RESPONSE TO SUBMISSIONS REPORT

SSD 34919690 – MOD 2
39-43 HASSALL ST PARRAMATTA

APRIL 2025

Drawing / Section A

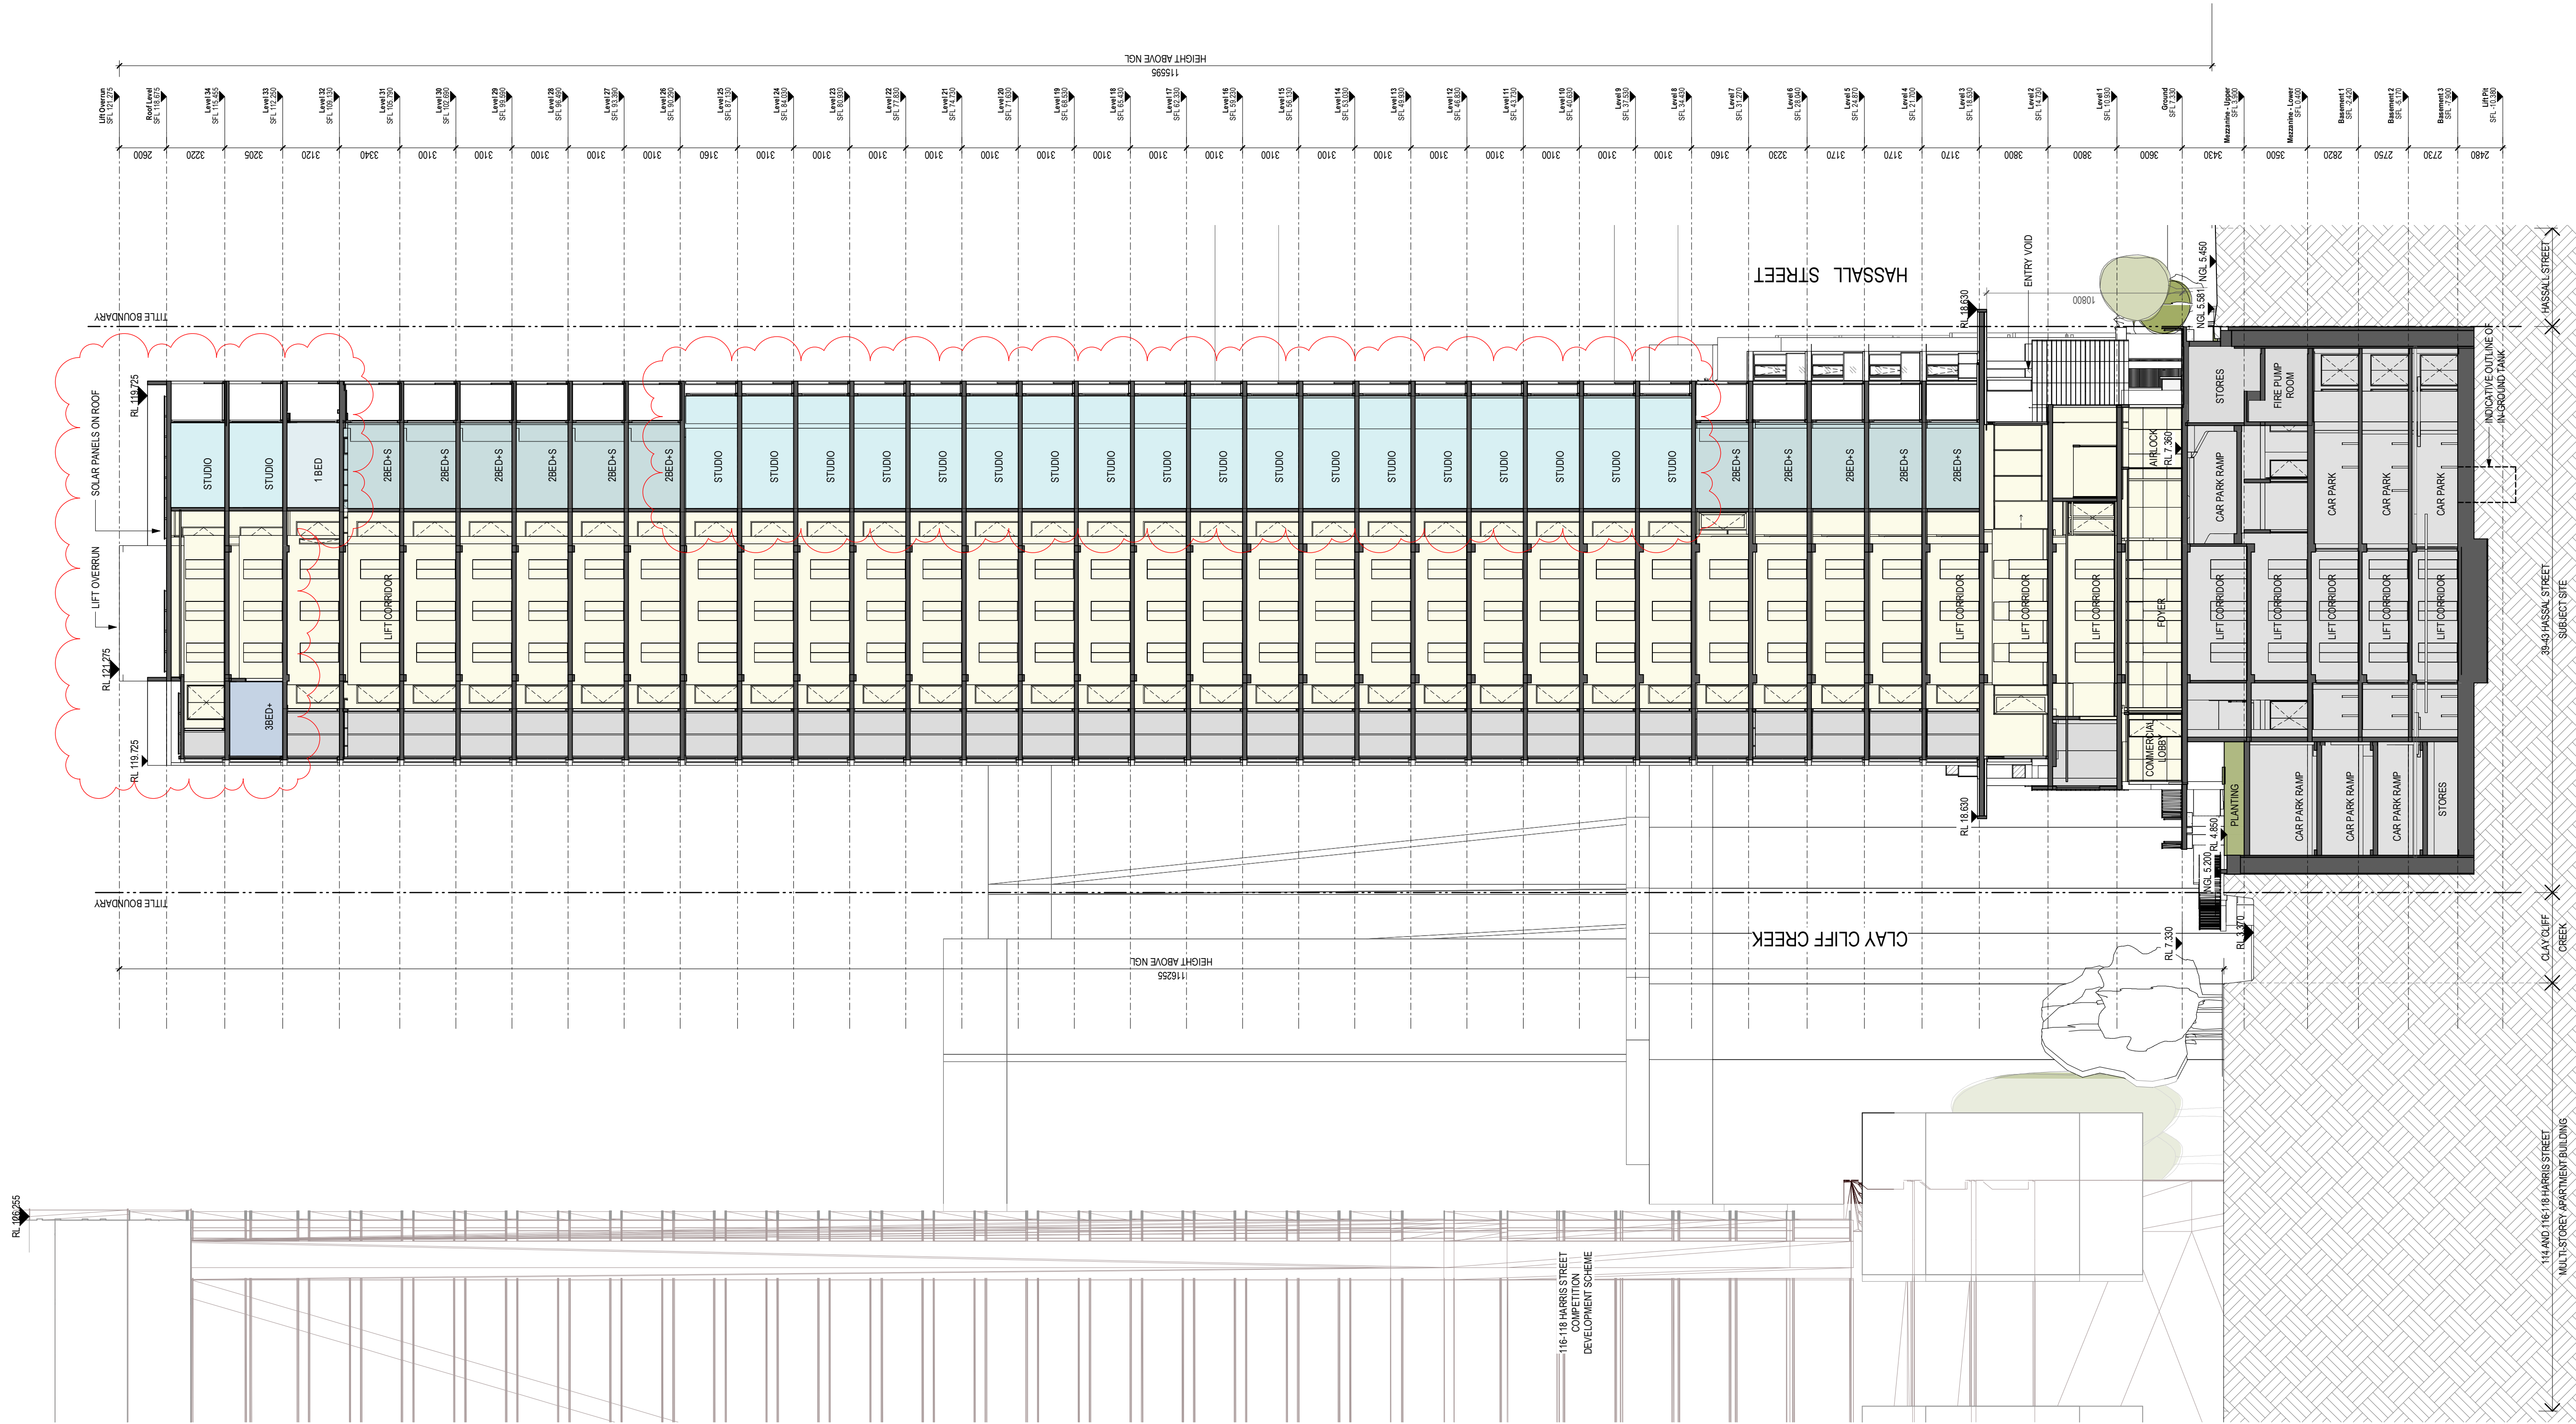
○ Section A of the landscape report does not show the basement structure only 1.2m from the boundary extent, below the proposed planting strip/riparian zone. ○ Planting on structure details are to be provided showing substrate depth, drainage, waterproofing for all planting on structures, including planting over the basement at ground level. ○ Soil volume, depth and soil areas on podium and over the basement must meet the following prescribed standards in the Apartment Design Guide (ADG) – Part 4, 4P <i>Planting on Structures – Tools for improving the design of residential apartment development</i> (NSW Department of Planning and Environment, 2015): ▪ Typical tree planting on structure detail to show overall 800-1200mm soil depth. ▪ Soil volume to be reflective of proposed tree species size	The landscape plan has been amended to show basement extent in Section A. Please see attached amended plans for details. Planting on structure details has been provided on Sheet 701 please see attached landscape plan for further details. Trees are only proposed within the ground floor. Planting on structure diagram has been provided on page 15. Soil Depth and volume are both compliant with the provisions of the ADG.
